City of Albuquerque

***Public Works Department
Transportation Development Services Section***

December 12, 2001

Re: TCL Submittal for Building Permit Approval for
Dr. Romero Office Building, [G20 / D27]
9300 Montgomery Blvd.
Architect's Stamp Dated 12/10/01

SITE PLAN

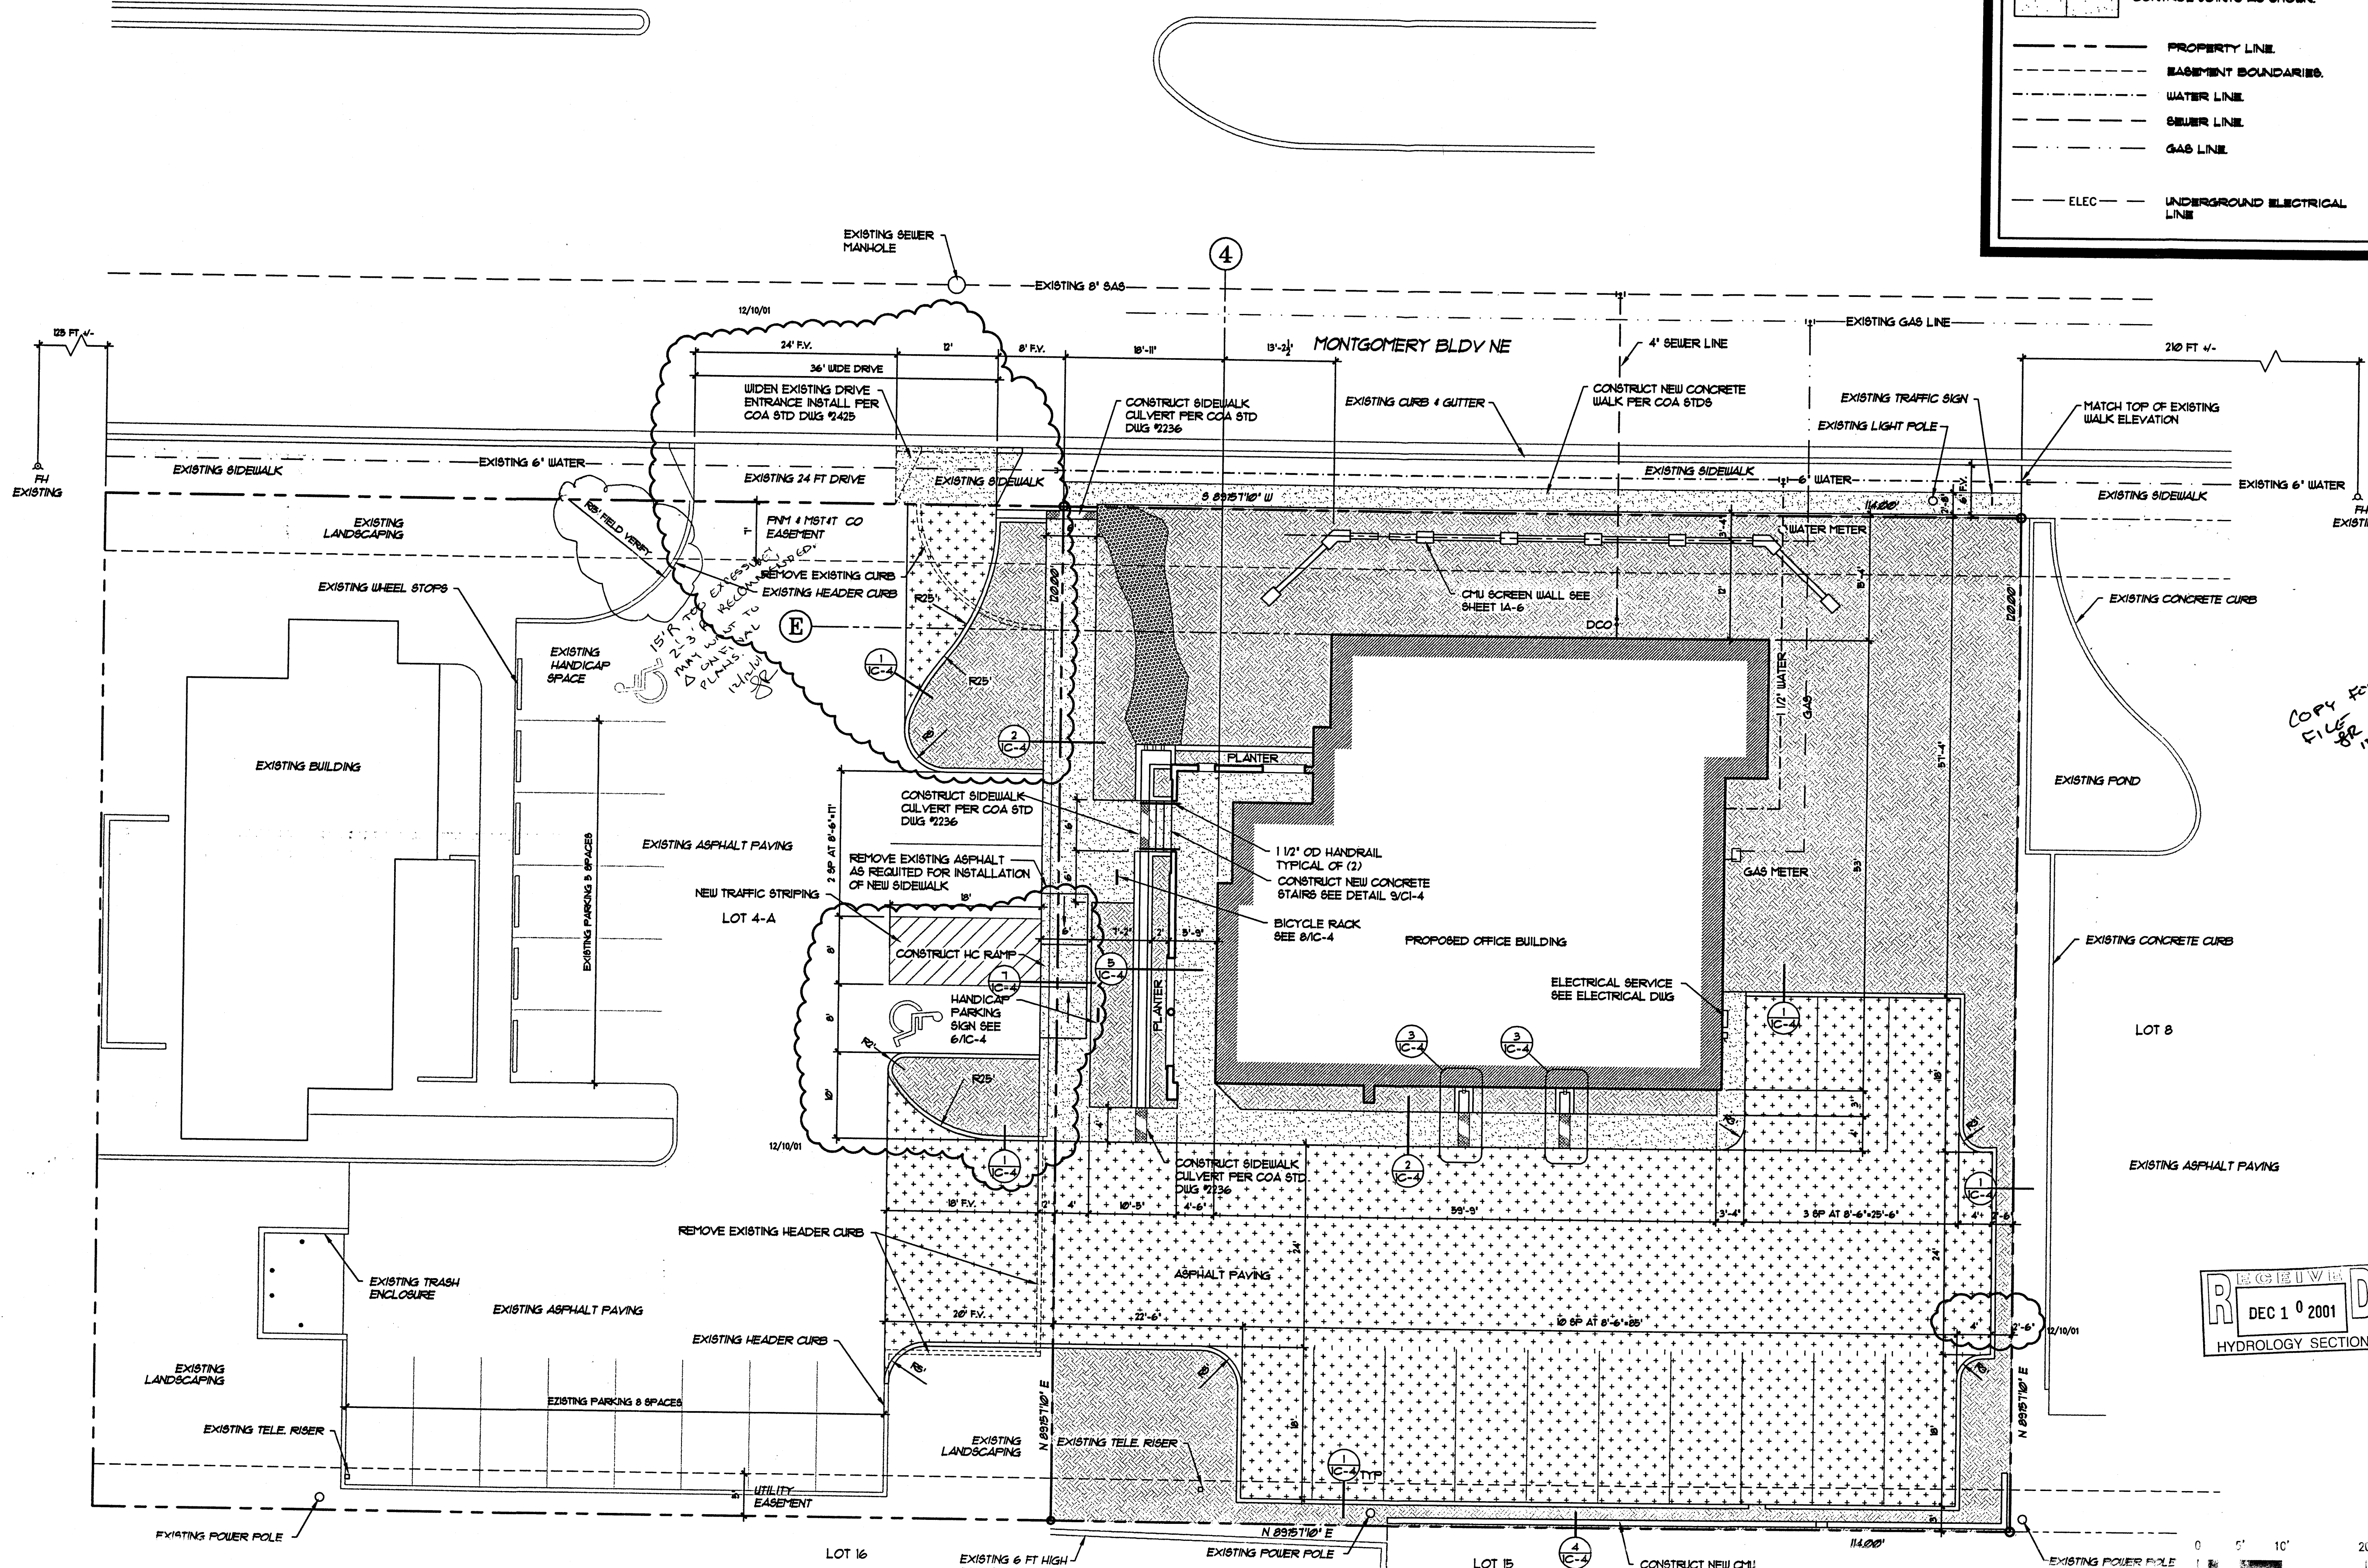
The location referenced above is not acceptable and requires modification to the Traffic Circulation Layout (TCL) prior to Building Permit release. It is strongly recommended to make the noted adjustment on the site plan for the 25 feet radius curb-return driveway. The plan showing a transition-type drive pad can be approved as proposed. However, for safety's sake, the curb return is preferred. In addition, approval of this site without refuse enclosure is dependent on acceptance by Solid Waste.

3 SIDEWALK CULVERT
SCALE: AS NOTED

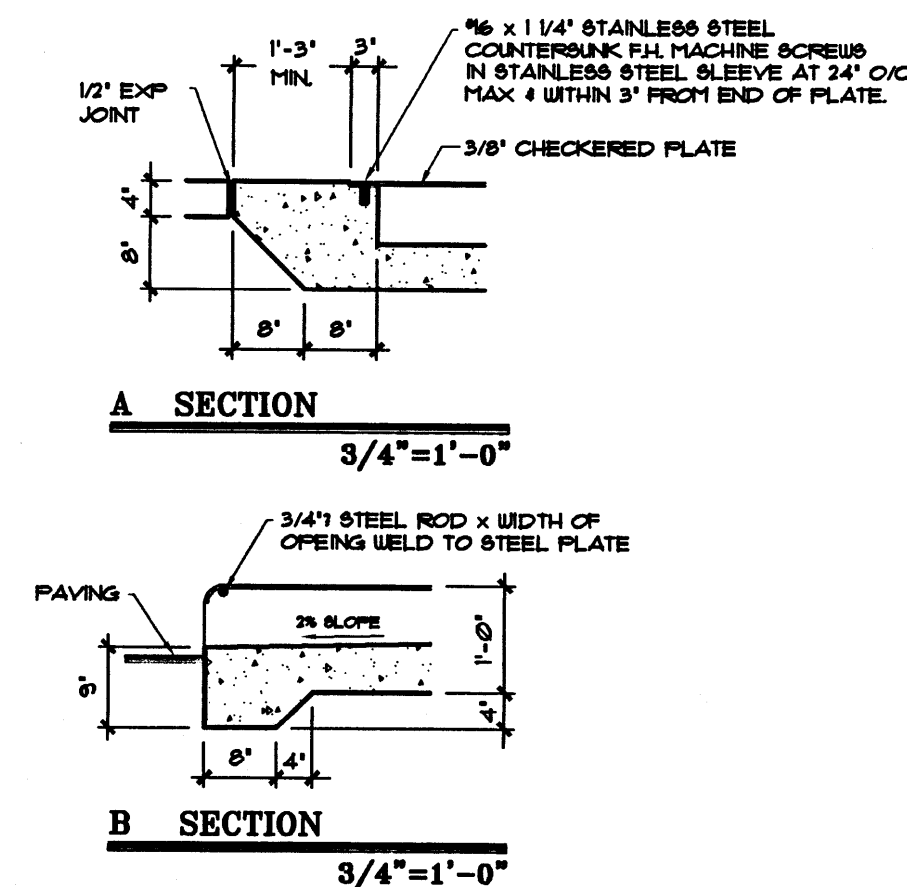
Indicate the size of the sidewalk culverts.
